**RE: Telopea Concept Plan and Stage 1A Residential, Retail, Child Care and Aged Care –  
Adderton Road, Telopea – SSD-14378717  
Transport and Accessibility Impact Assessment Addendum**

The objective of this TAIA Addendum is to provide responses to the traffic and transport related RFIs received from City of Parramatta Council (Council), NSW Department of Planning, Industry and Environment (DPIE), and Transport for NSW (TfNSW).

1:250 NAT

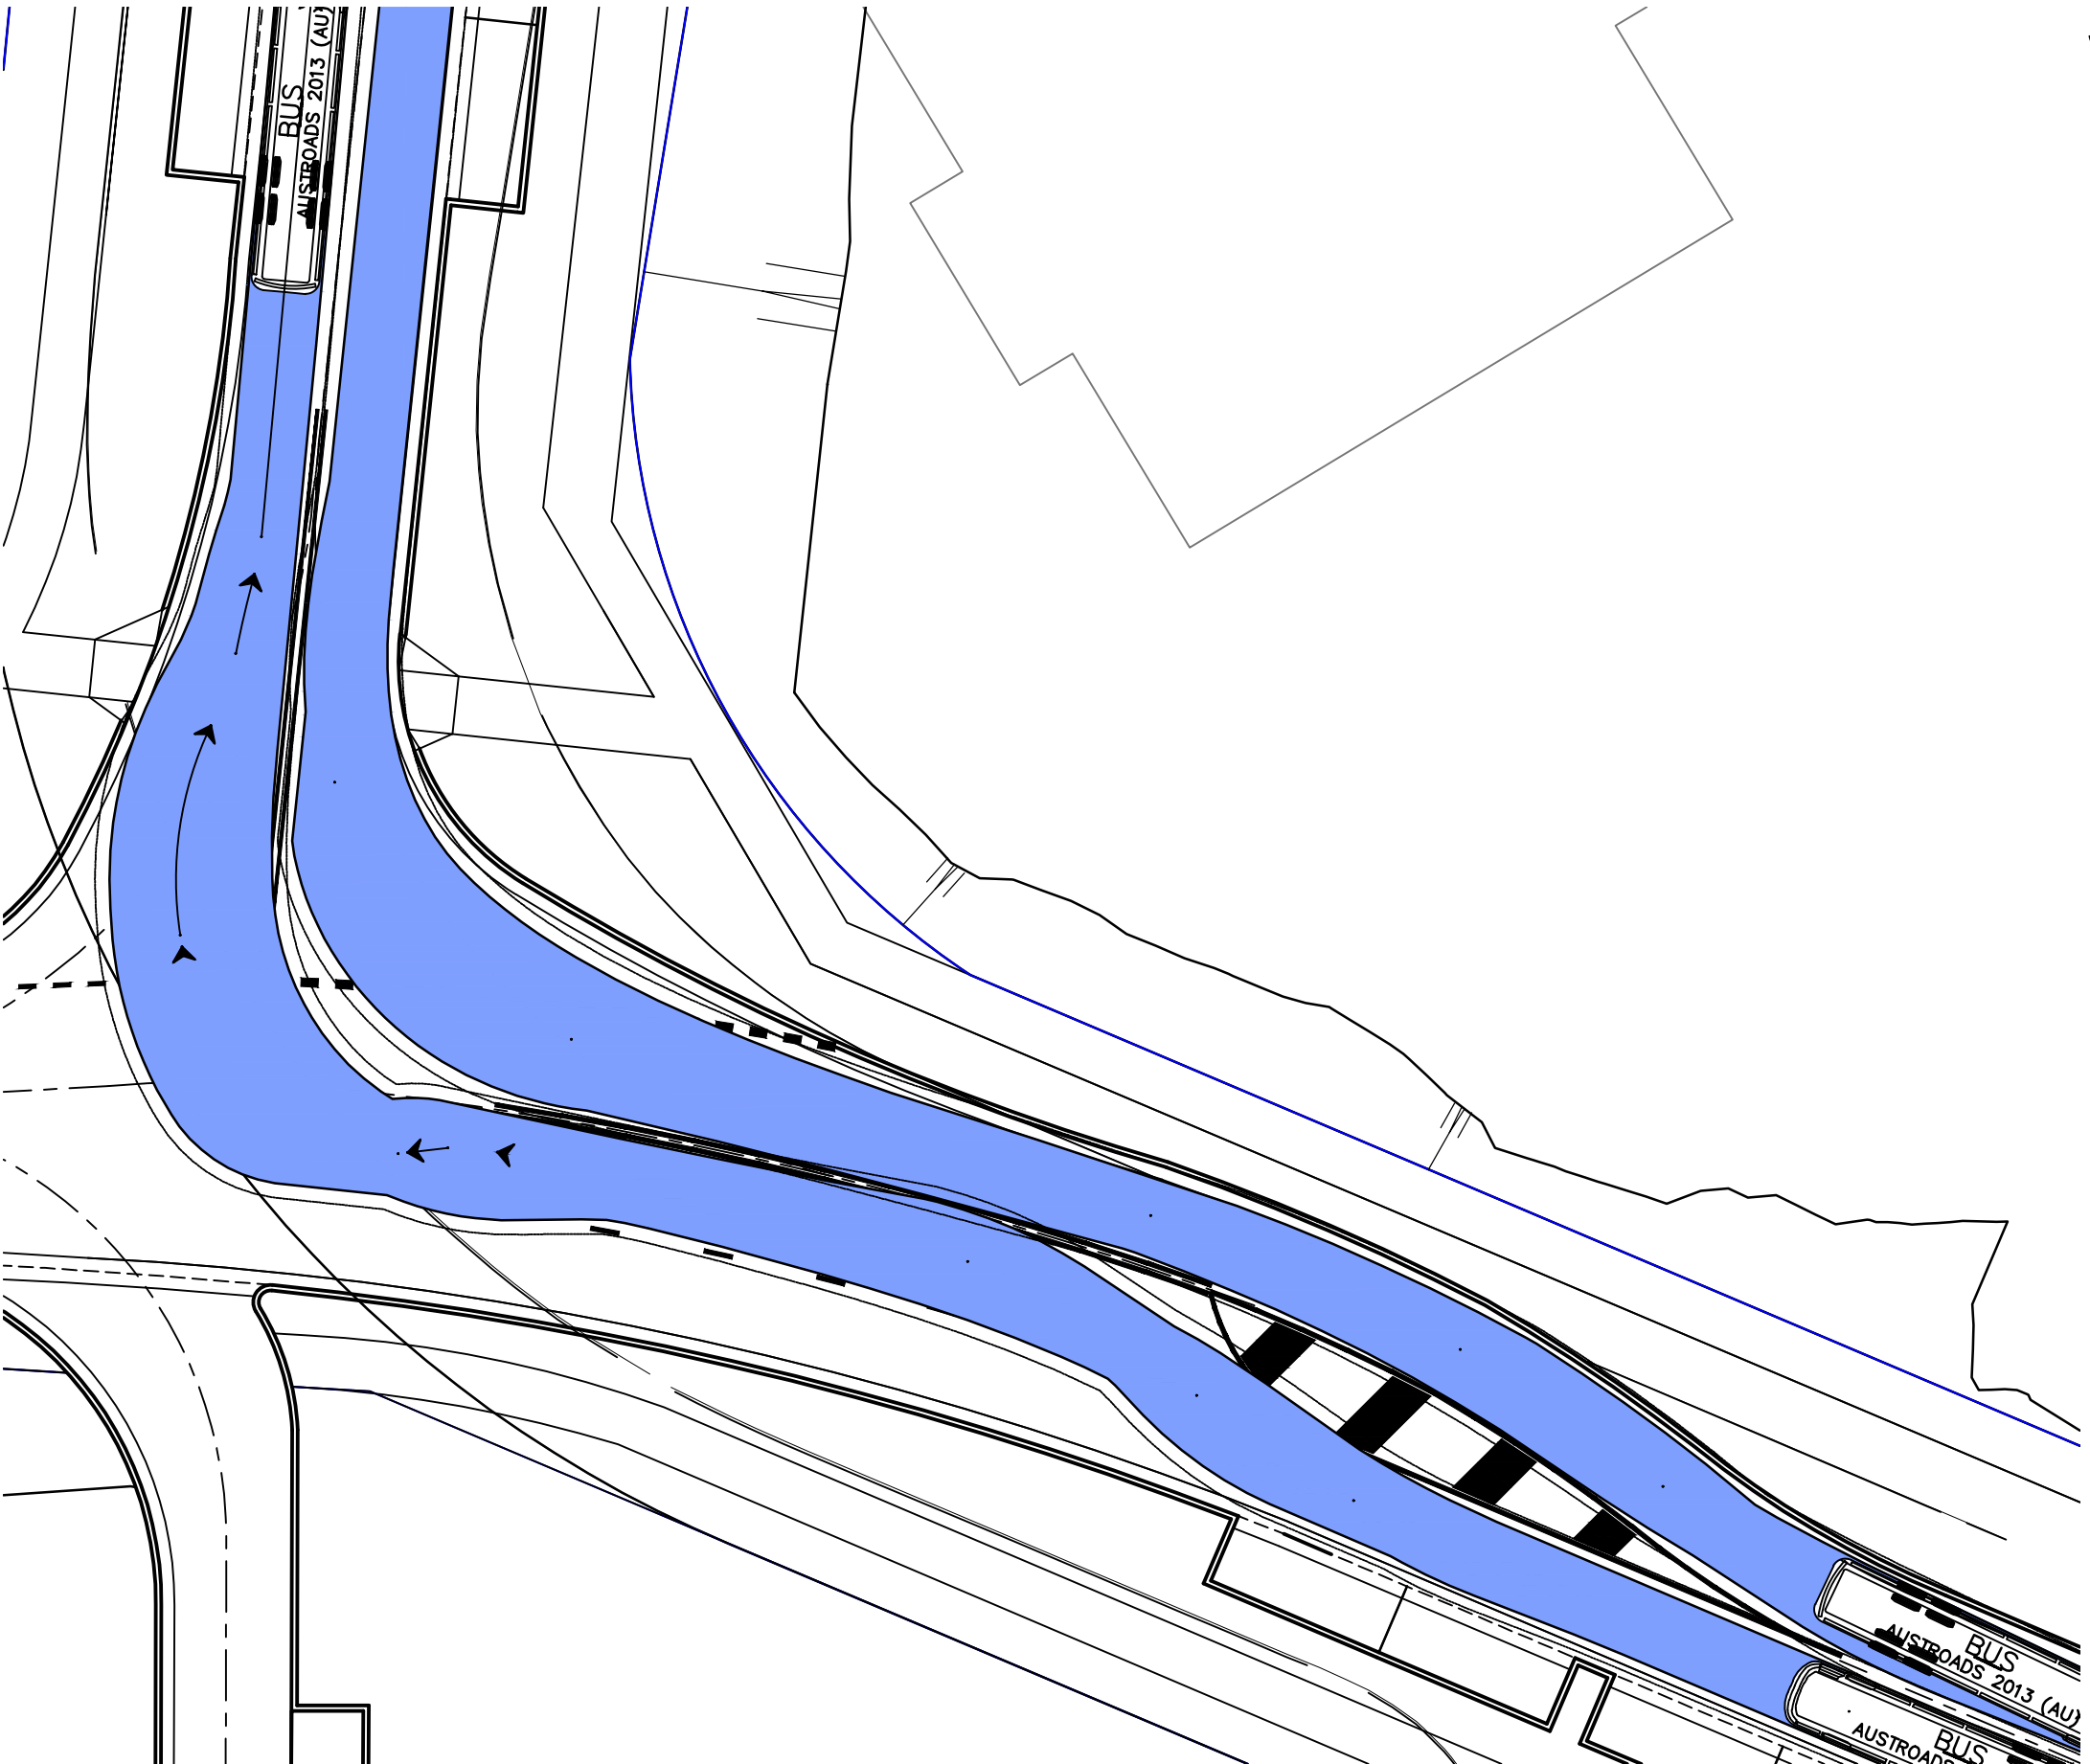
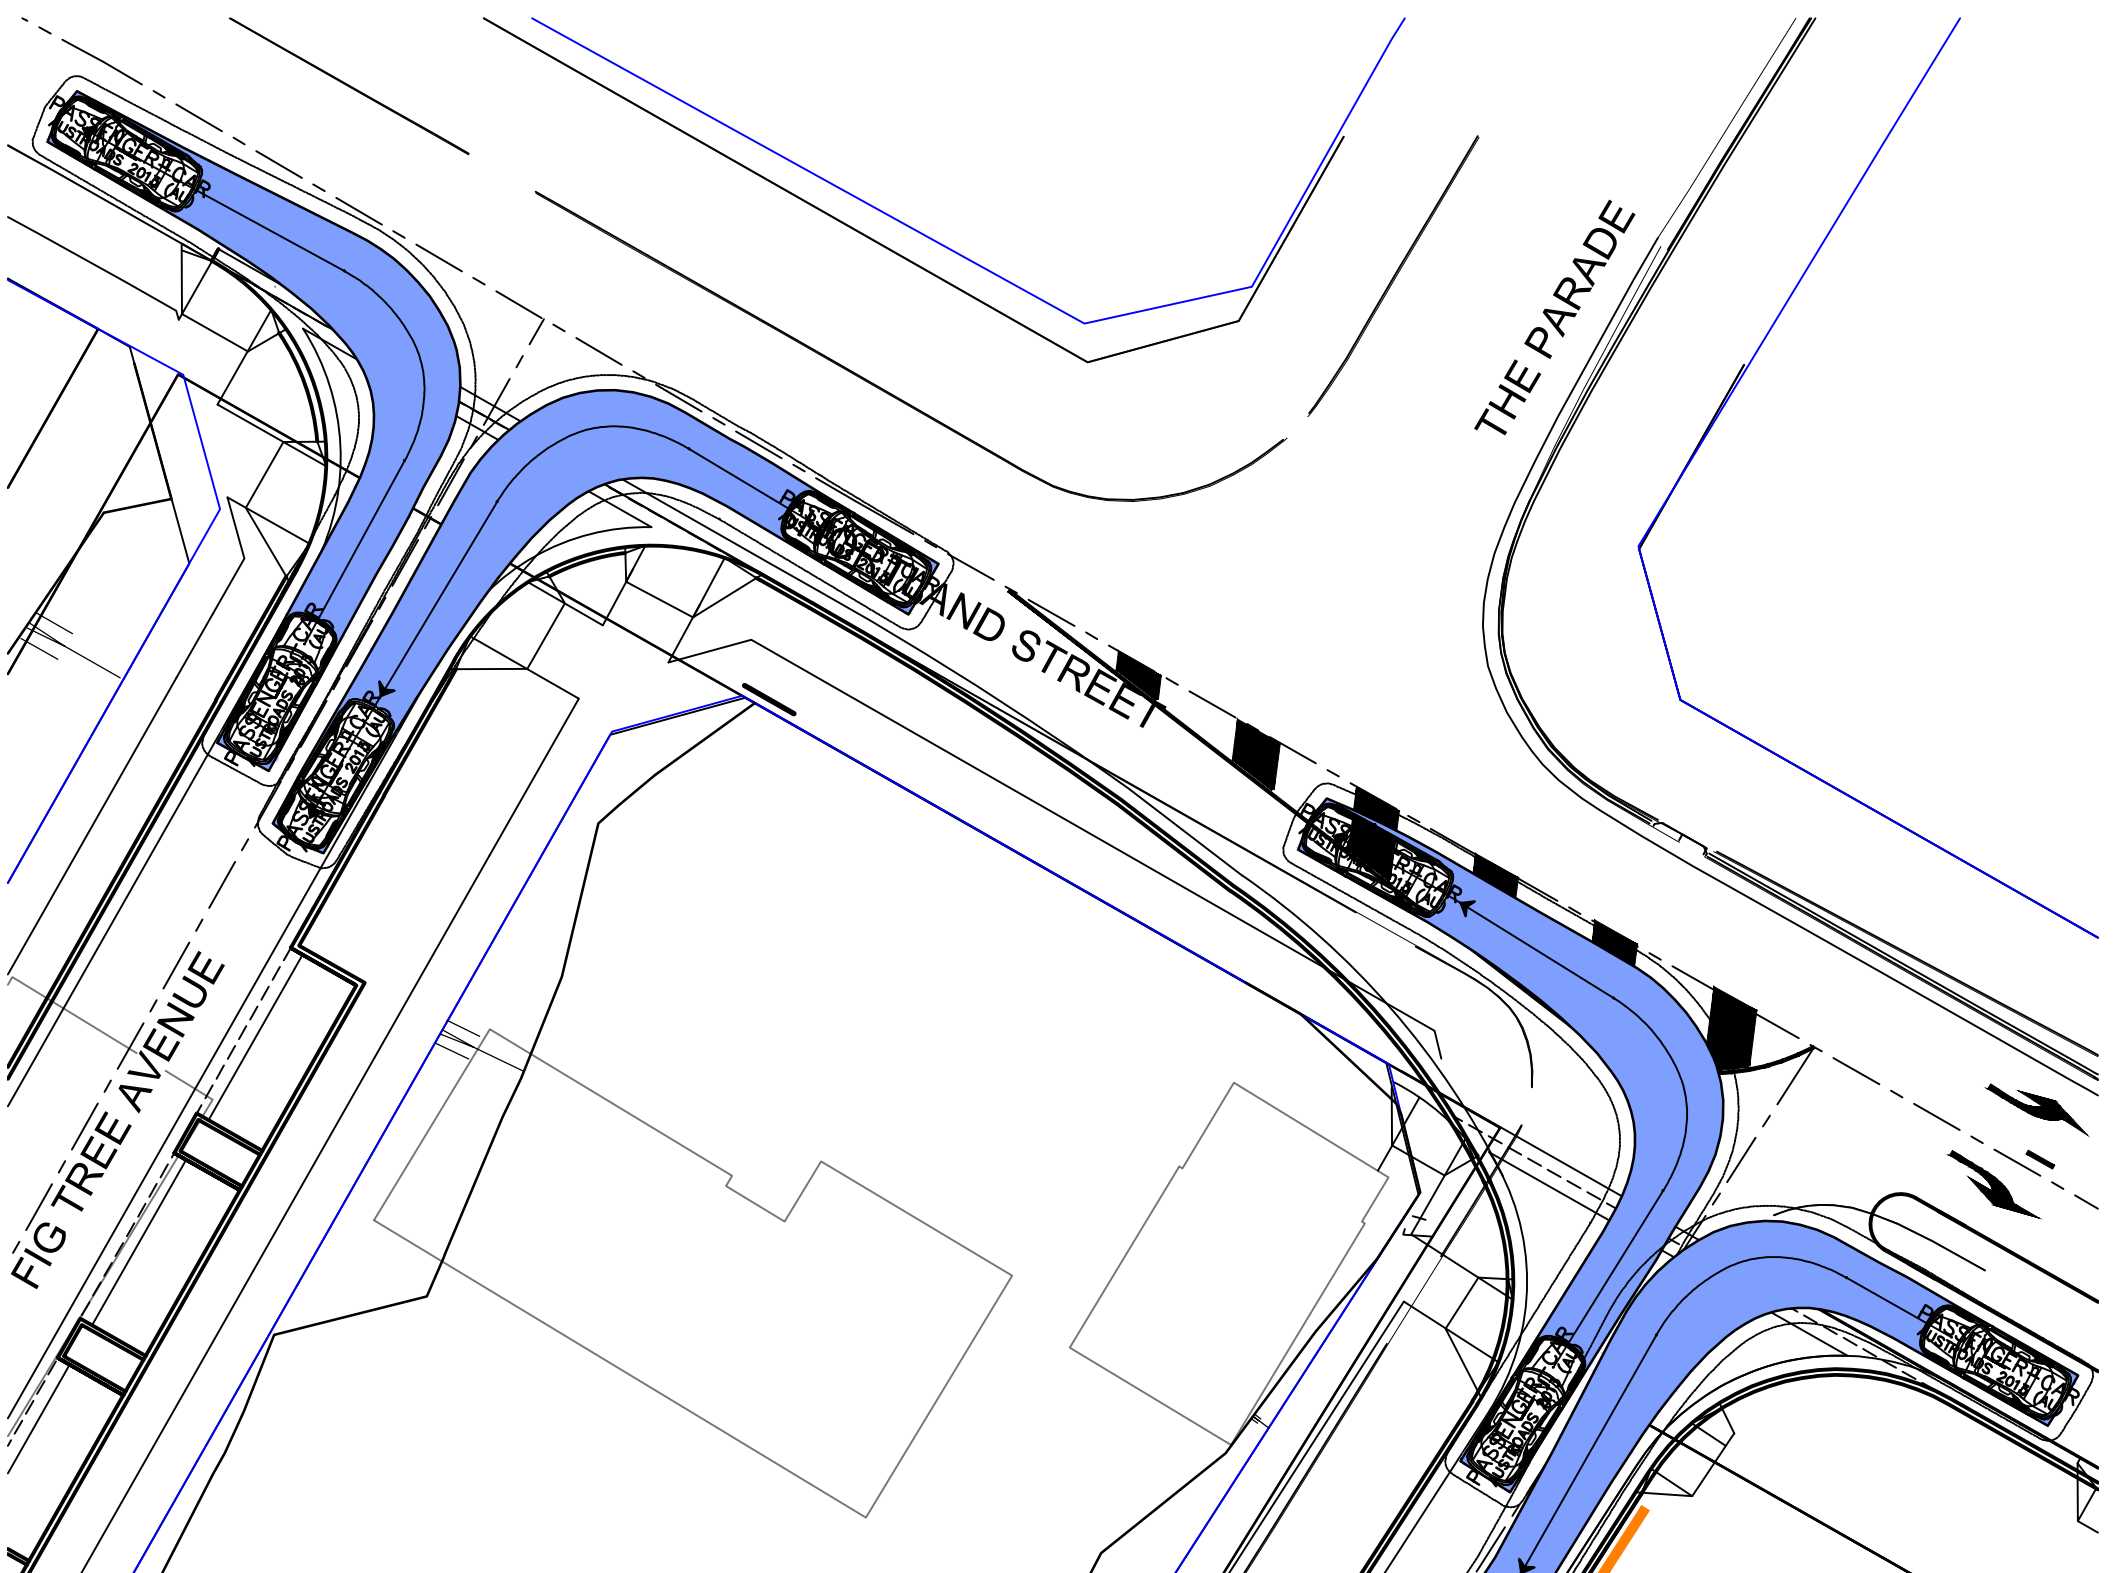
<p><b>14</b></p>	<p><b>Waste Management</b></p>	
<p><b>14.2 Comments (Attachment B) - Waste Truck</b></p>	<p>Trucks are required to enter and exit in a forward direction and the use of a turn table is not permitted. Council requires trucks to be able to enter and exit in a forward within a threepoint turn. From the provided plans, it is not clear whether the waste holding area is located sub-street level. Further detail is required to understand the access, as access into areas below street level is generally not supported. Council also requires 4.5M clearance height throughout the truck's entire travel path. All paths travelled by a waste truck will need to be rated to support a 25t vehicle.</p>	<p>The use of a turntable for service vehicle trucks is acceptable as it is permitted under relevant Australian Standards and is used at a number of developments within Greater Sydney, including elsewhere in the City of Parramatta.</p> <p>Conversely, to design for a 12.5m HRV truck to enter in a forward direction, manoeuvre on-site for loading and then exit in a forward direction would result in a significant impact on the development and would represent a poor design outcome for a vehicle that only occasionally requires access to the Site.</p>
